From: Finlay Gardner <Finlay.Gardner@arun.gov.uk>
Sent: 19 May 2021 19:56
To: Planning.Responses <Planning.Responses@arun.gov.uk>
Subject: FW: Objection to 339 Chichester road

Please attach as rep to BE/59/21/PL

SITE PLAN - SHOWING VISIBILITY SPLAYS
1:500 SCALE (at A3)

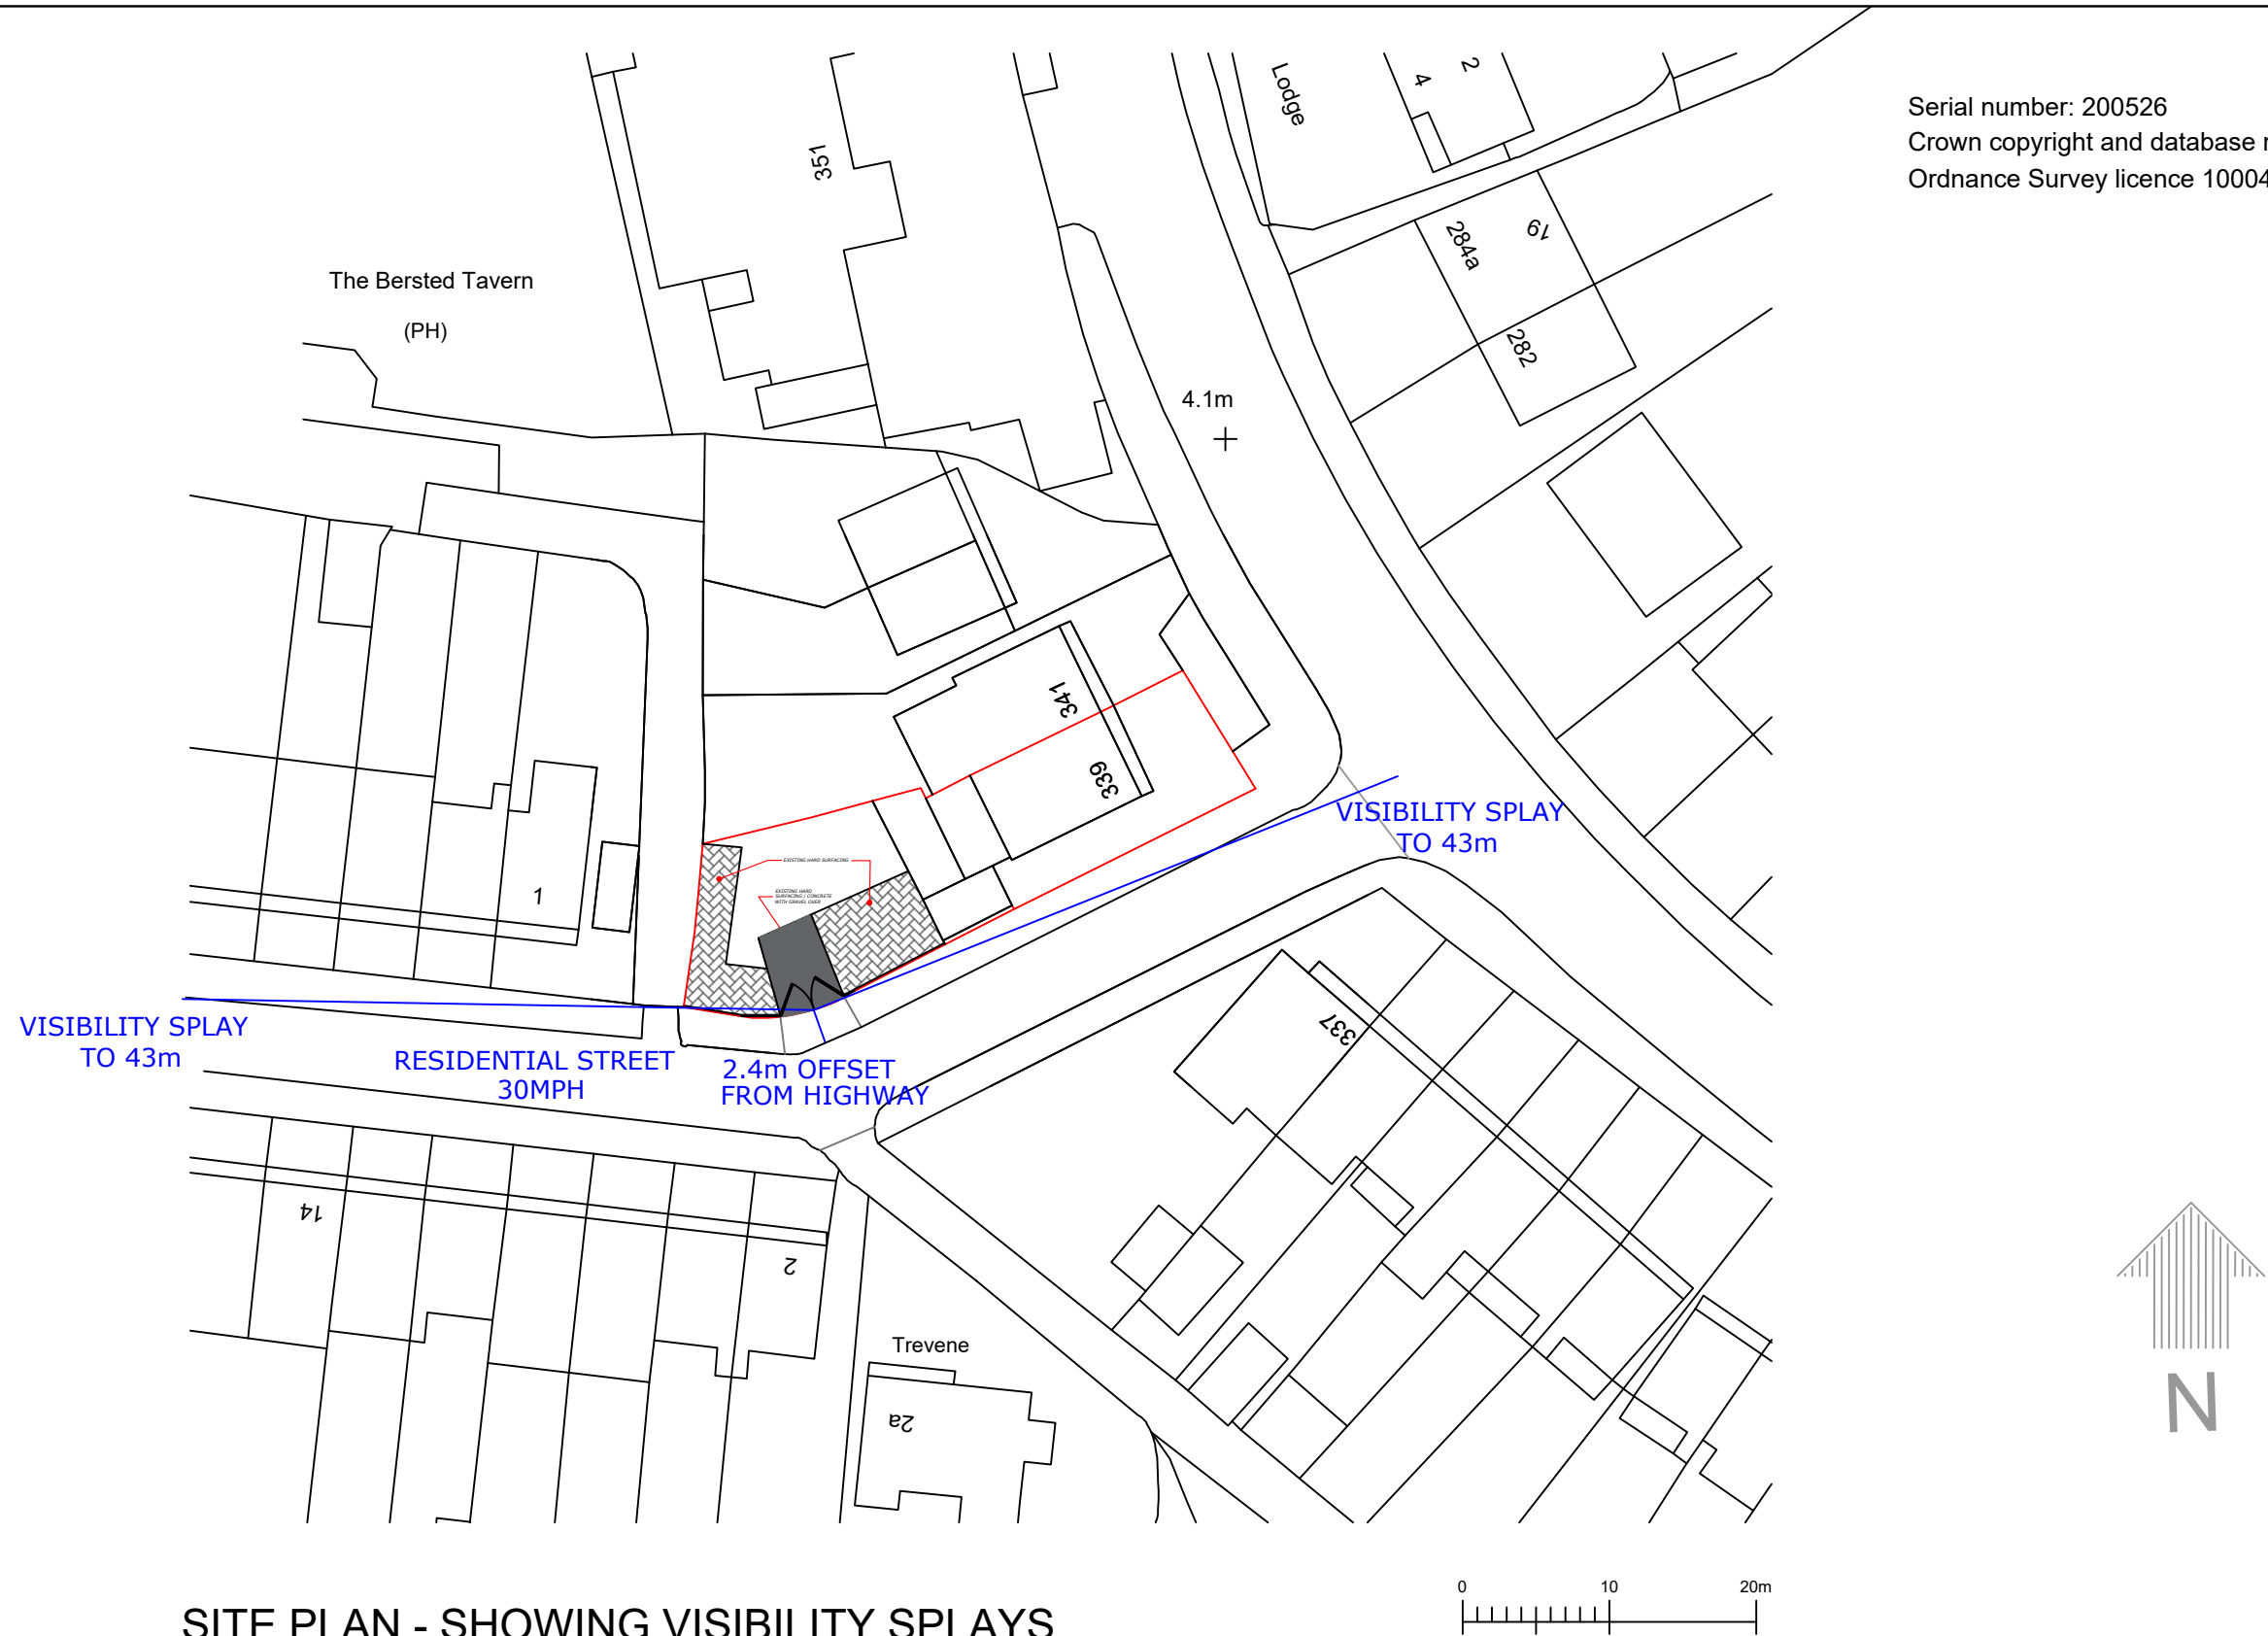
I am concerned about Mr Delaney's (339 Chichester road) planning application to develop an entrance on Bedford avenue as well as him not having planning permission to install the drop kerb but doing it anyway.
